**Tilbuster Solar Farm (SSD-9619)
Request for additional information**

I refer to the Submissions Report and the Amendment Report for the Tilbuster Solar Farm. The Department has carefully reviewed both reports and requests the following:

Tilbuster Solar Farm Sites In Relation To Development Footprint

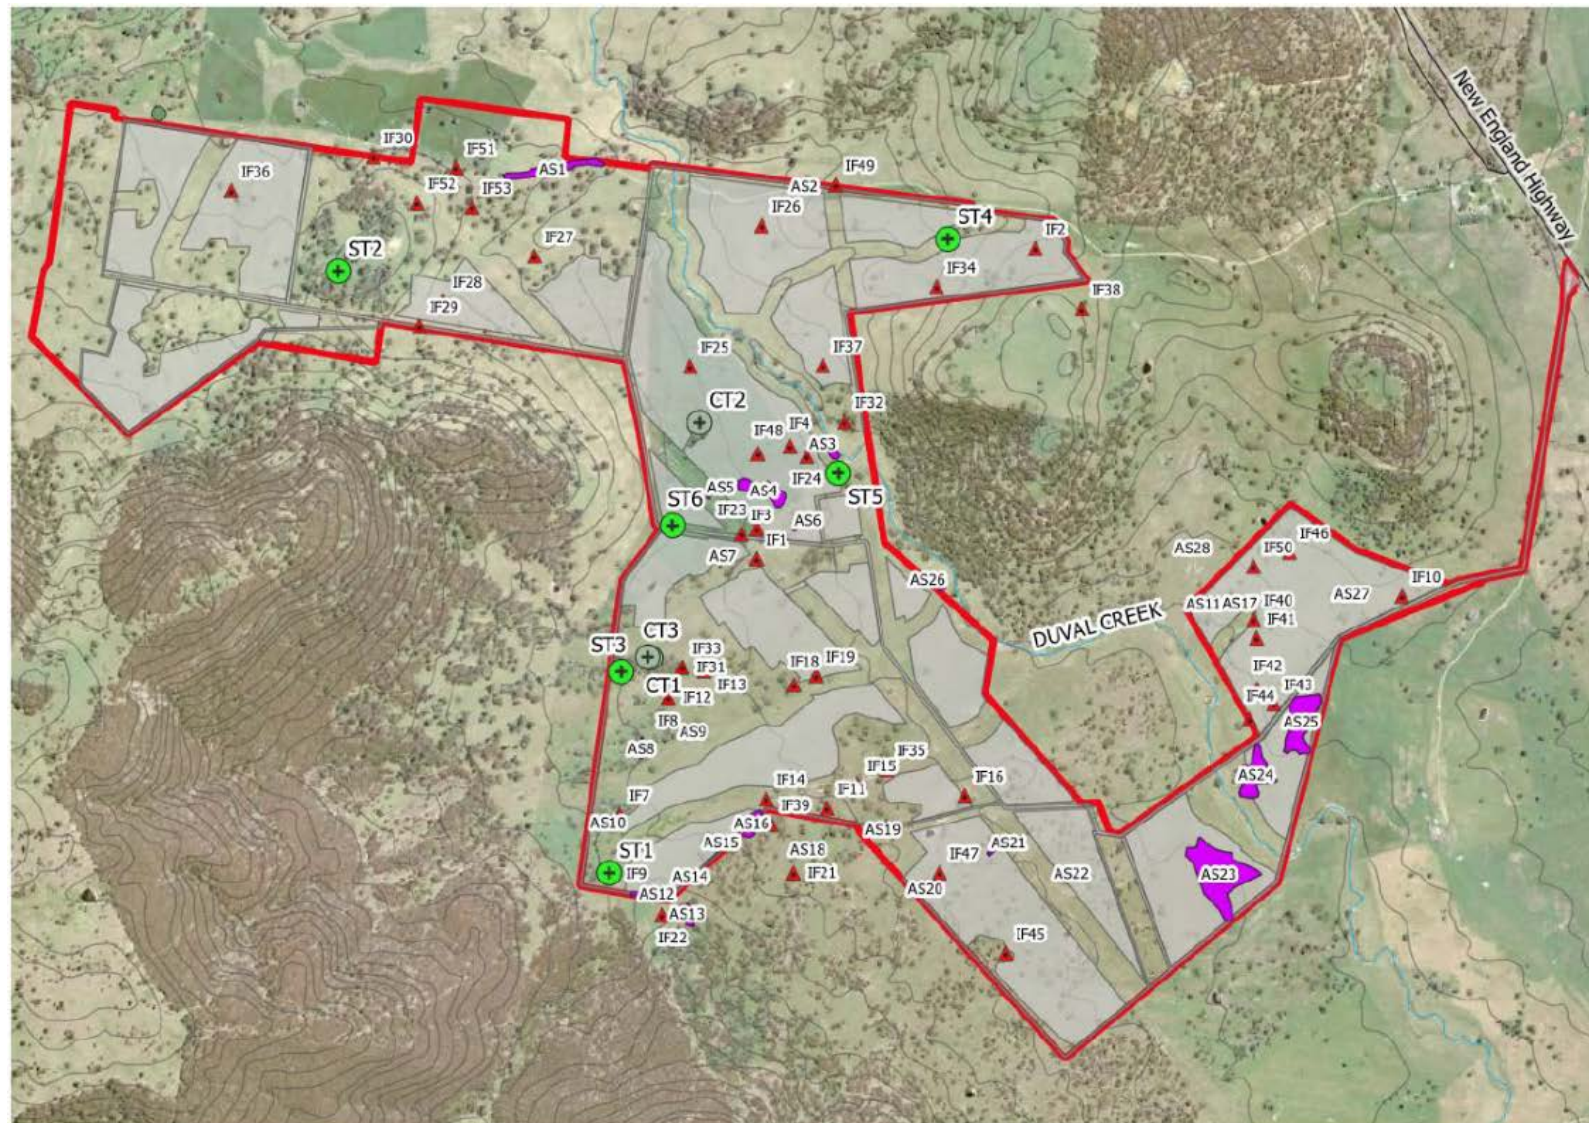
- Review the mitigation measures presented in the figures and tables of the amended Aboriginal Cultural Heritage Assessment Report which propose salvage works for items outside the development footprint.

Figure 4 | Site constraints

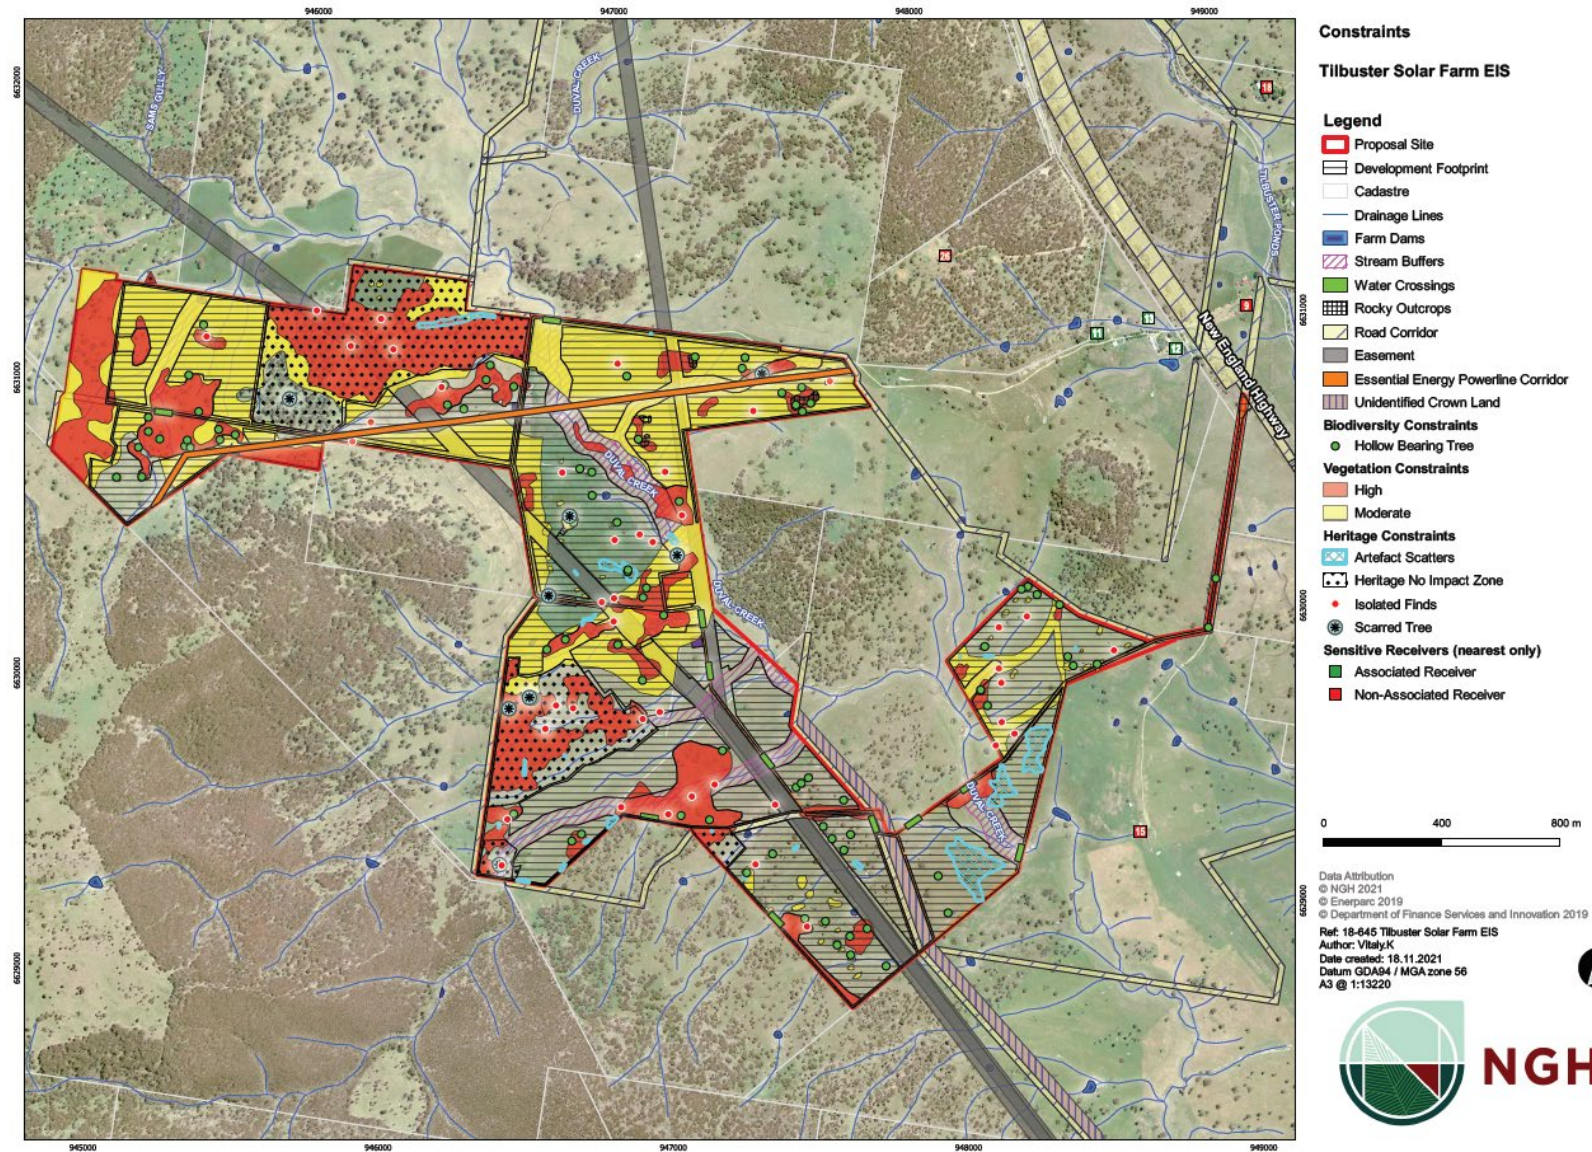
- Clarify the size of the development footprint (noting conflicting numbers are presented in the documents).
- Provide a high quality constraints map showing surrounding receiver locations, existing utilities including the TransGrid and Essential Energy easements and location of water crossings.
- Provide further justification for the location of infrastructure or amend the development footprint to avoid the riparian corridor of 3rd order streams.
- Respond to the request from Armidale Council to include an additional area to accommodate a splay on the southern corner of the proposed road intersection upgrade and associated subdivision plan to facilitate this.

Figure 7 | Surrounding receivers and zone of visual influence

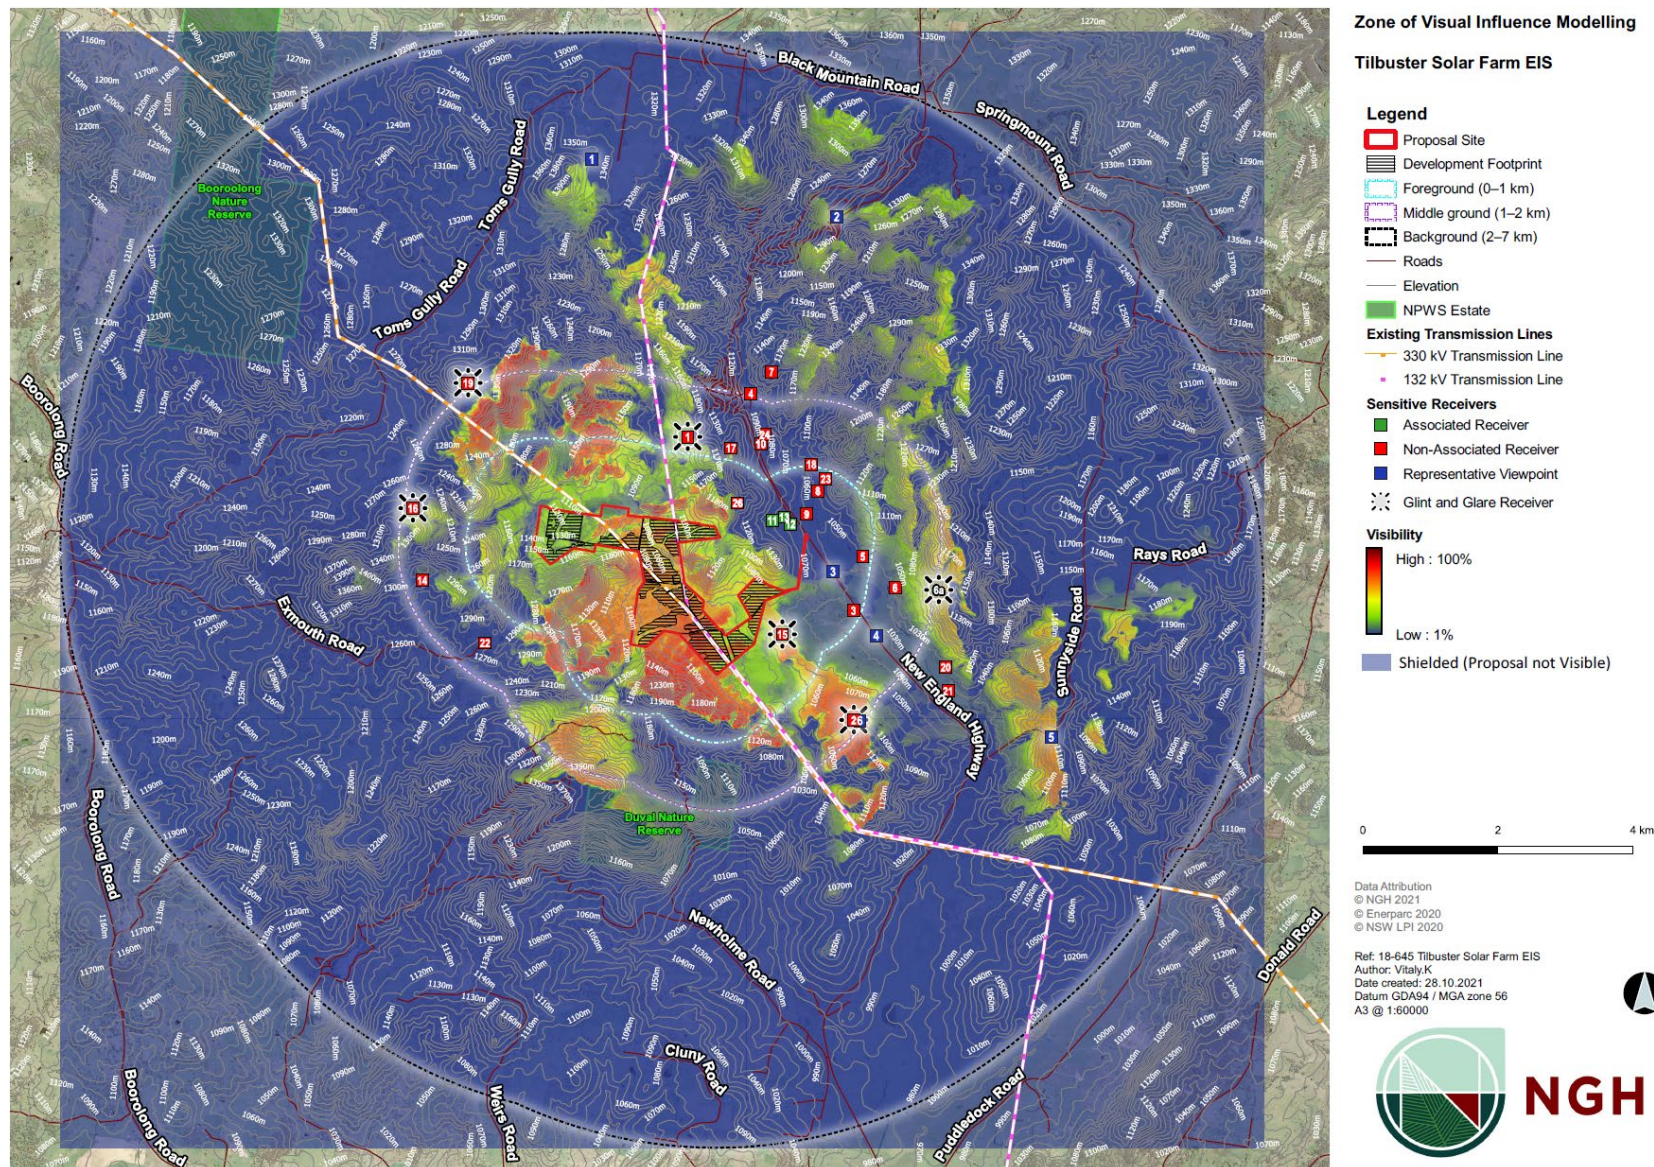
- Provide further justification of the assessment of glint and glare provided in the Amendment Report.
- Confirm the table of distances between receivers to site and receivers to the nearest project infrastructure.
